CITY OF ALBUQUERQUE

PLANNING DEPARTMENT – Development Review Services

August 7, 2015

RE: **Multi-Specialty Clinic
Drainage Report and Conceptual Grading and Drainage Plan
Engineer's Stamp Date 7-2-2015 (File: M15D026B)**

ENGINEER'S SEAL	MULTI-SPECIALTY CLINIC 2901 TRANSPORT ST, S.E.	DRAWN BY DY
	CONCEPTUAL GRADING AND DRAINAGE PLAN	DATE 7/01/15
RONALD R. BOHANNAN P.E. #7868	TIERRA WEST, LLC 5571 MIDWAY PARK PLACE NE ALBUQUERQUE, NM 87109 (505) 858-3100 www.tierrowestllc.com	2015044-GRE
		SHEET # C1
		JOB # 2015044

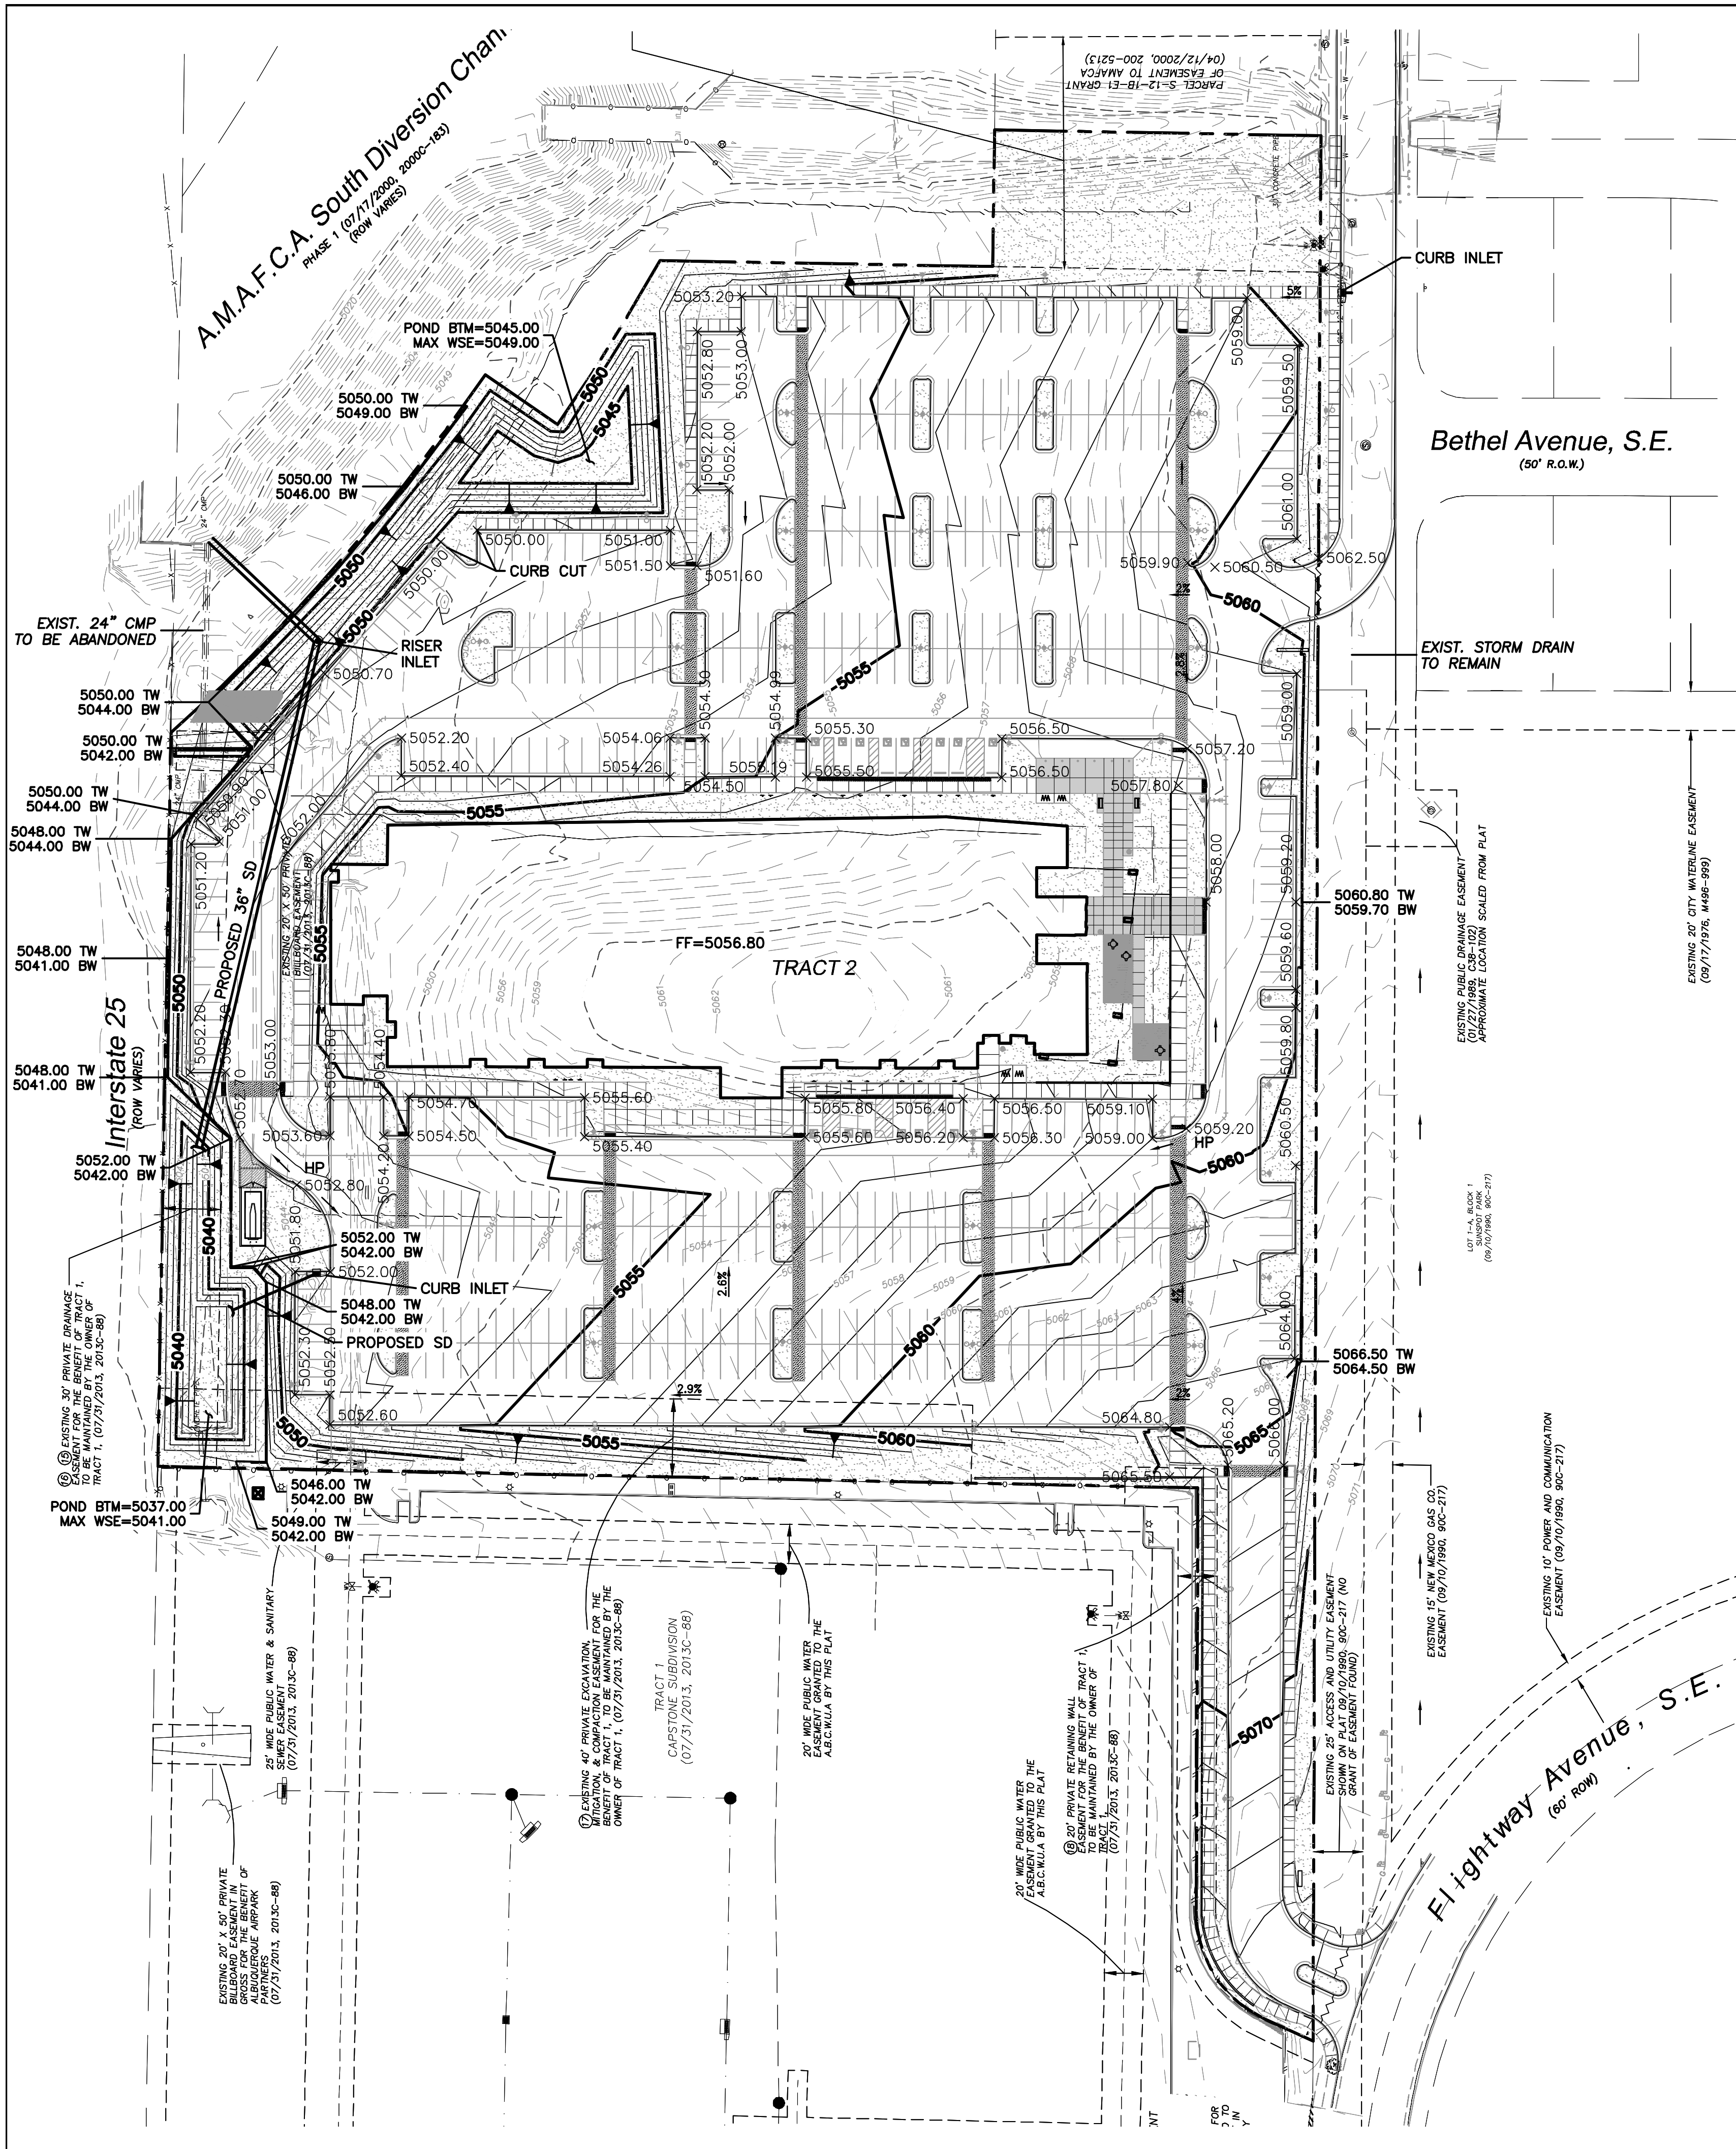
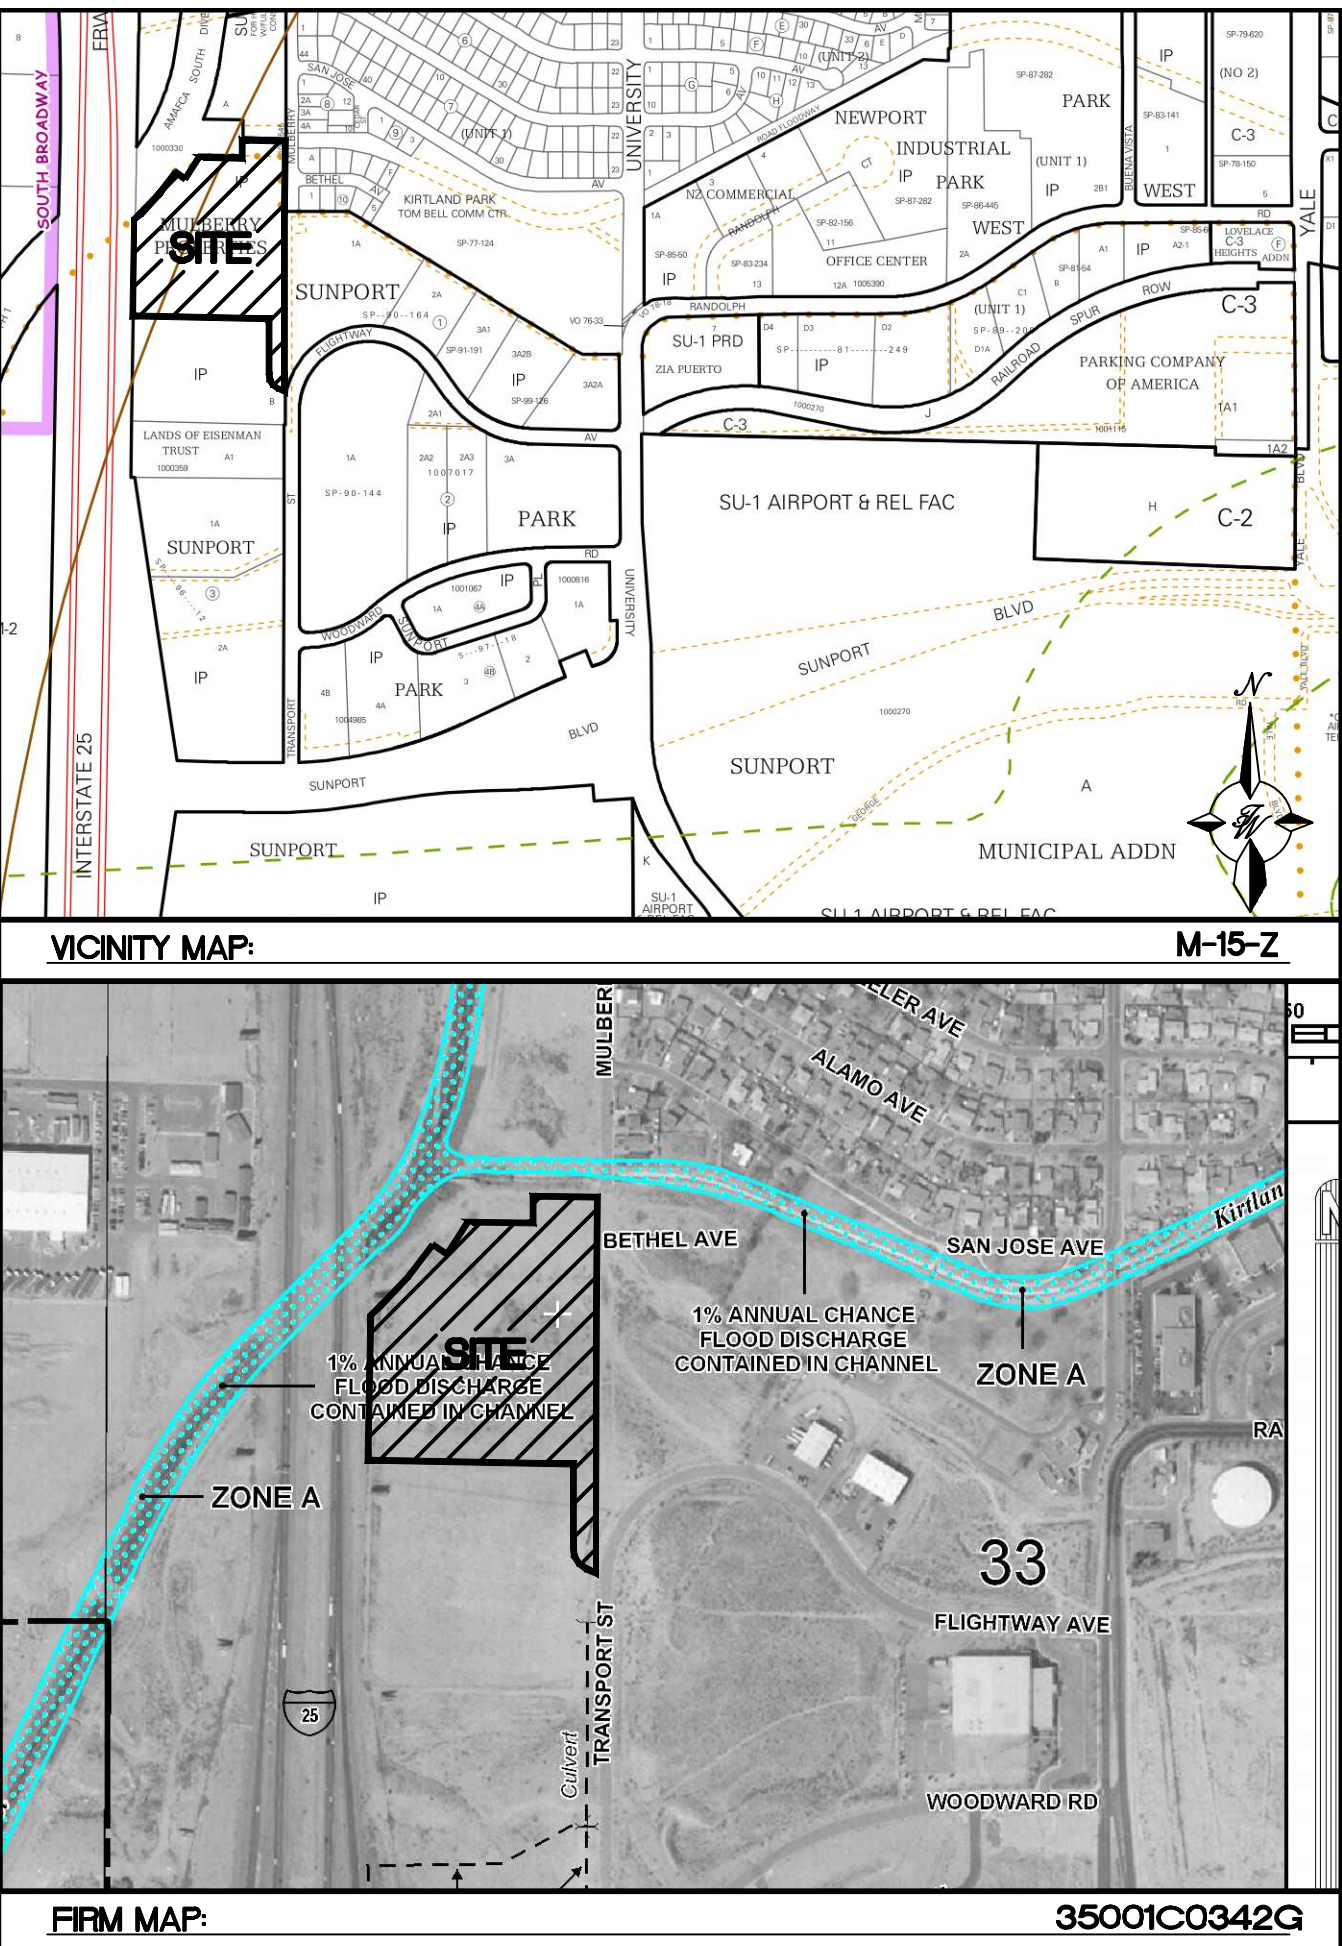
3. Attach significant excerpts and basin map from the Drainage Management Plan for Capstone in an appendix.
4. In the Drainage Report, pg.3: Revise the 2nd paragraph. It incorrectly states that the more southern pond accepts flows from the northern pond. Also, it would be helpful to label ponds on the maps and plans as Pond 1, and Pond 2, and refer to them as such in the report.

5. On the Grading Plan show the Detention Pond and the 36" pipe from Phase 1.
6. Show/note the Emergency overflow for both ponds.
7. According to letter from AMAFCA dated June 25,2013, review of U.S. Army Corps of Engineers is required. Verify that this is required, and the reason.
